Our Case Number: ABP-309770-21

Re: Proposed development of up to 15 wind turbines with a tip height of up to 175 metres and laying of approximately 26km of underground electricity cabling to facilitate the connection to the national grid, and all associated site development works
Townlands of Camagh, Carlanstown, Coole, Clonrobert, Clonsura, Doon, Monktown, Mullagh, Newcastle and other townlands, Co. Westmeath

SID Further Information

wish to make an observation on the Further Information supplied in relation to
**Case reference: PA25M.309770: Townlands of Camagh, Carlanstown,
Coole, Clonrobert, Clonsura, Doon, Monkstown, Mullagh, Newcastle and
other townlands, Co. Westmeath.**

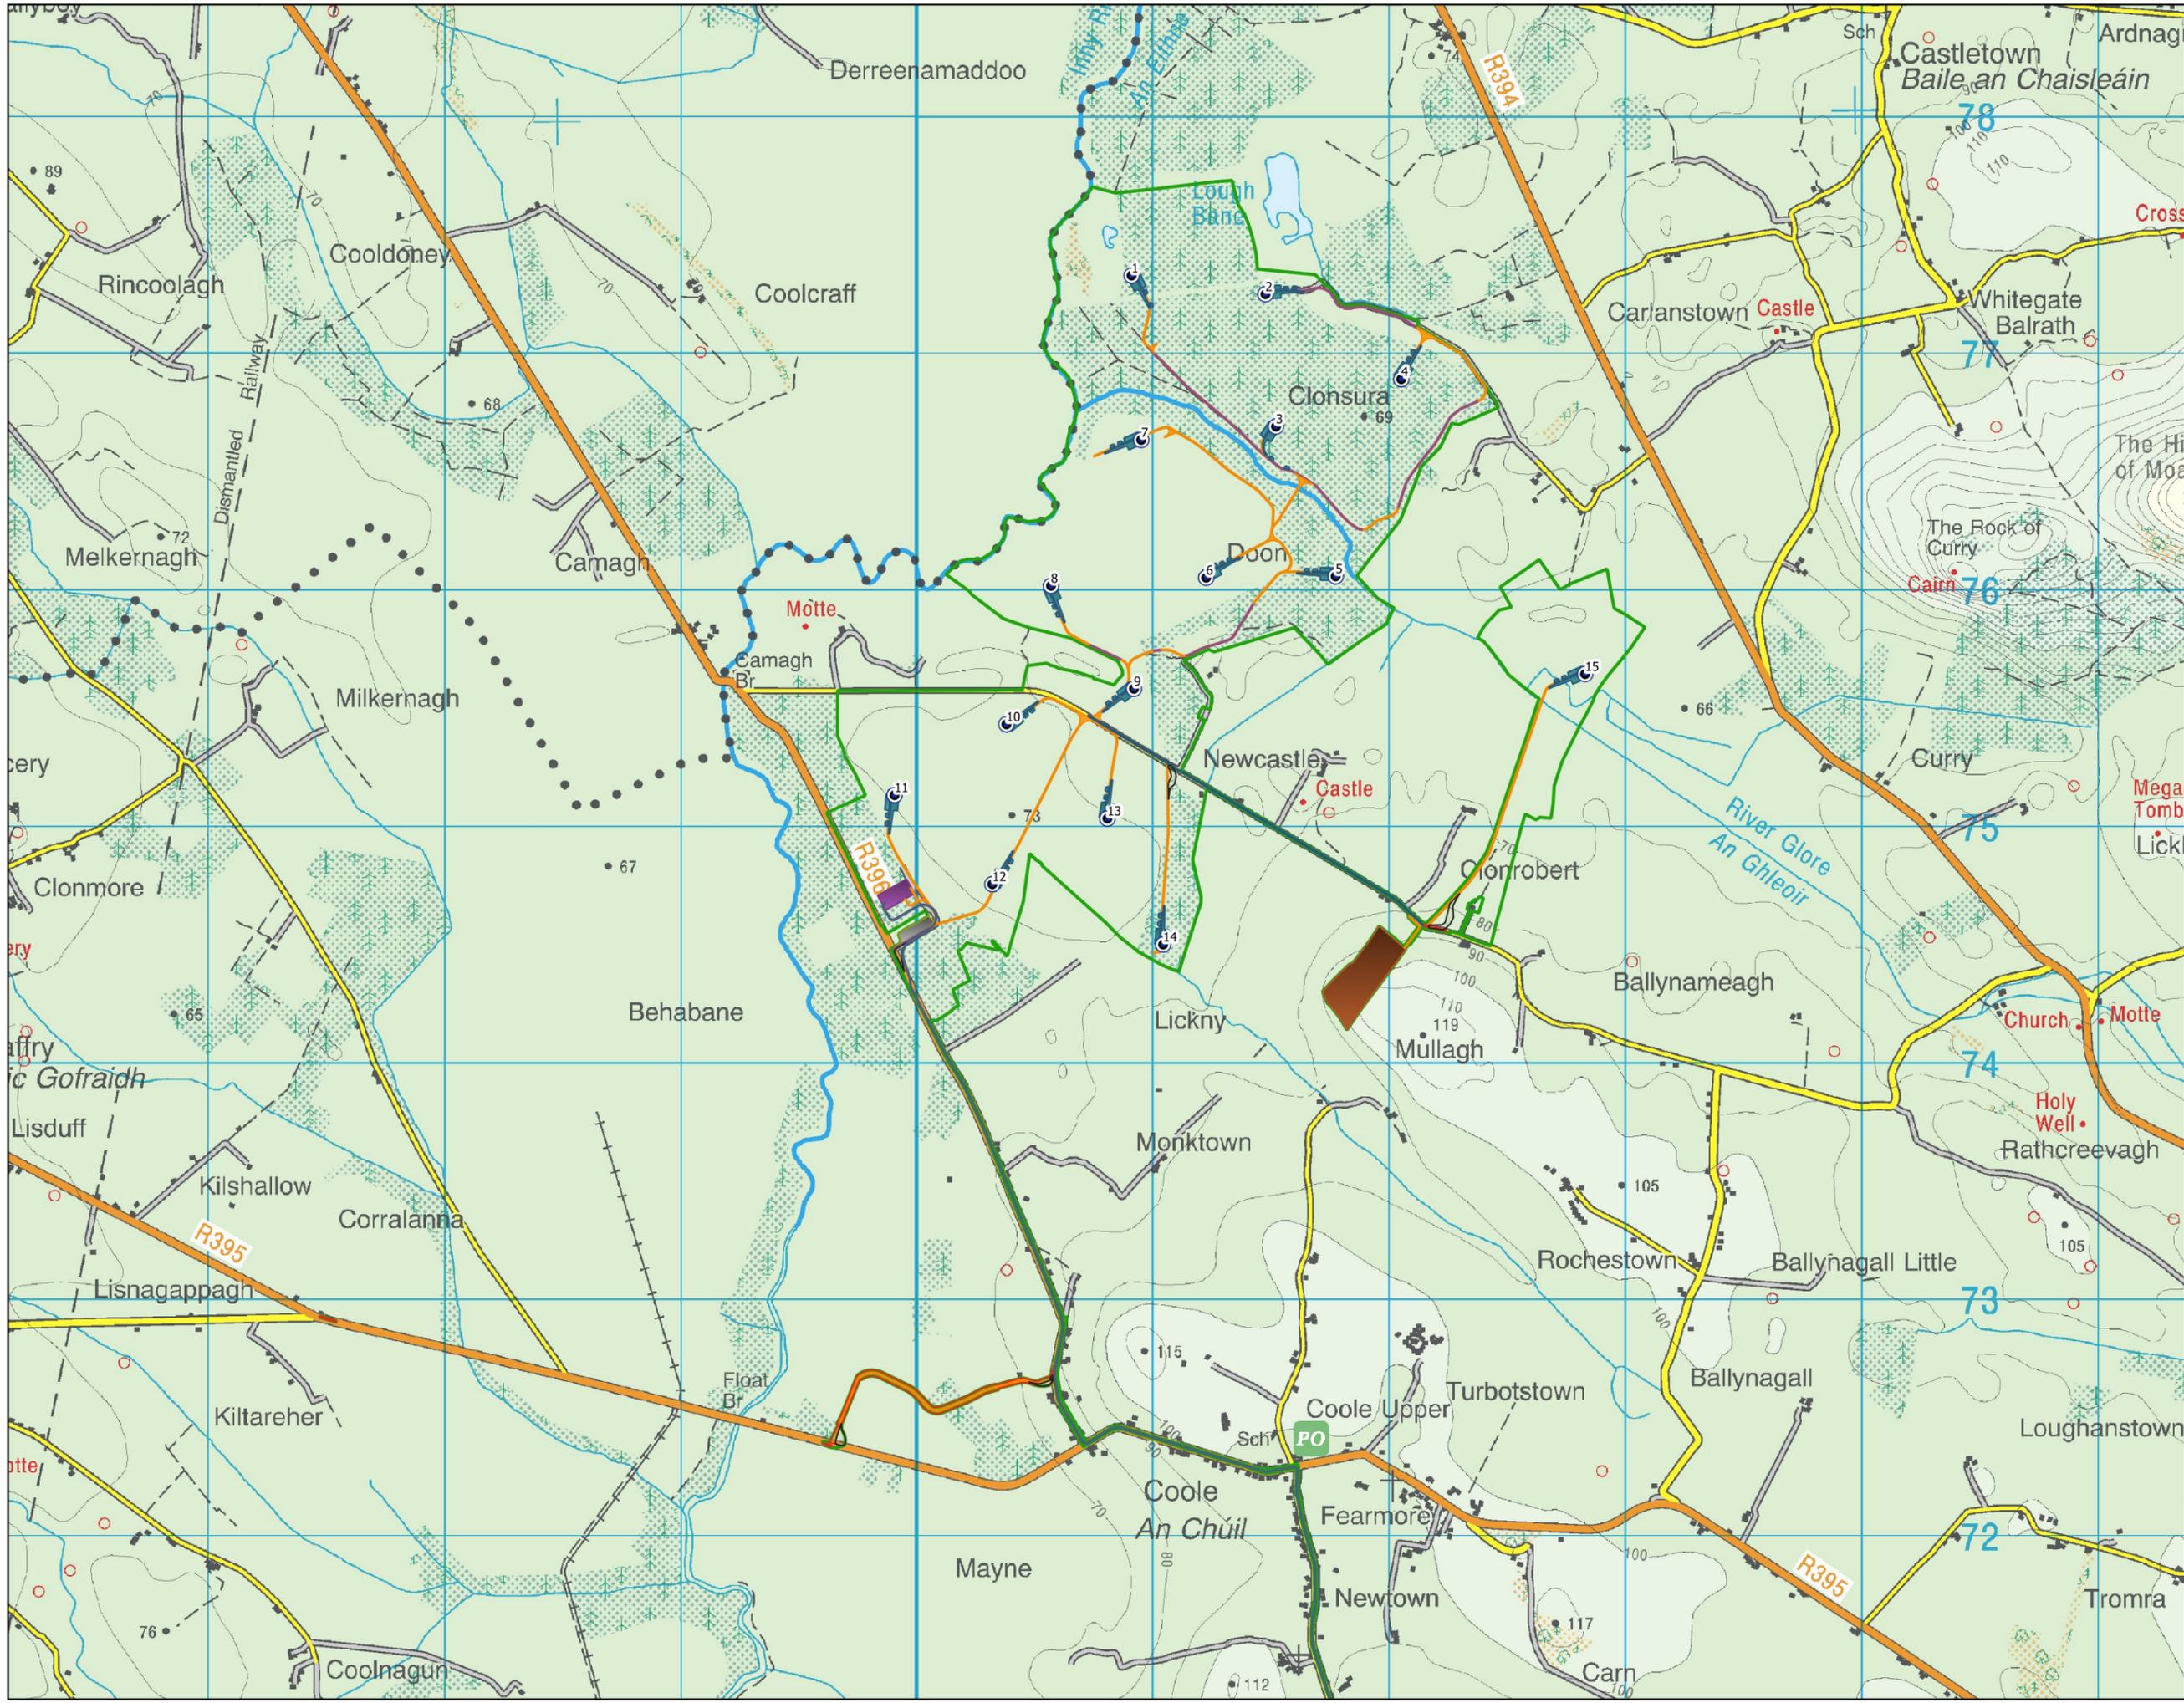
Point 4.3 Requests to demonstrate sufficient control over the existing drainage systems: In the revised NIS 5.4.1.1 Mitigation by Design it states: *All major infrastructure such as turbines, substations and site compounds will be over 50m from any main watercourse (identified on EPA watercourse mapper) and 10m from any large drainage channels on the site.* We would like to point out that on Turbine 1 the Crane Pad and Hardstanding area is actually built over a

watercourse, Turbine 5 the sweep of the turbine rotor goes over the River Glore and the foundation area is only 40metres from the river (but as there is no exact measurements for foundations it could be closer) and for Turbine 15 the Crane Pad Hardstanding area is also built over a watercourse. How will these watercourses be dealt with as the design does not mitigate pollution in these cases.
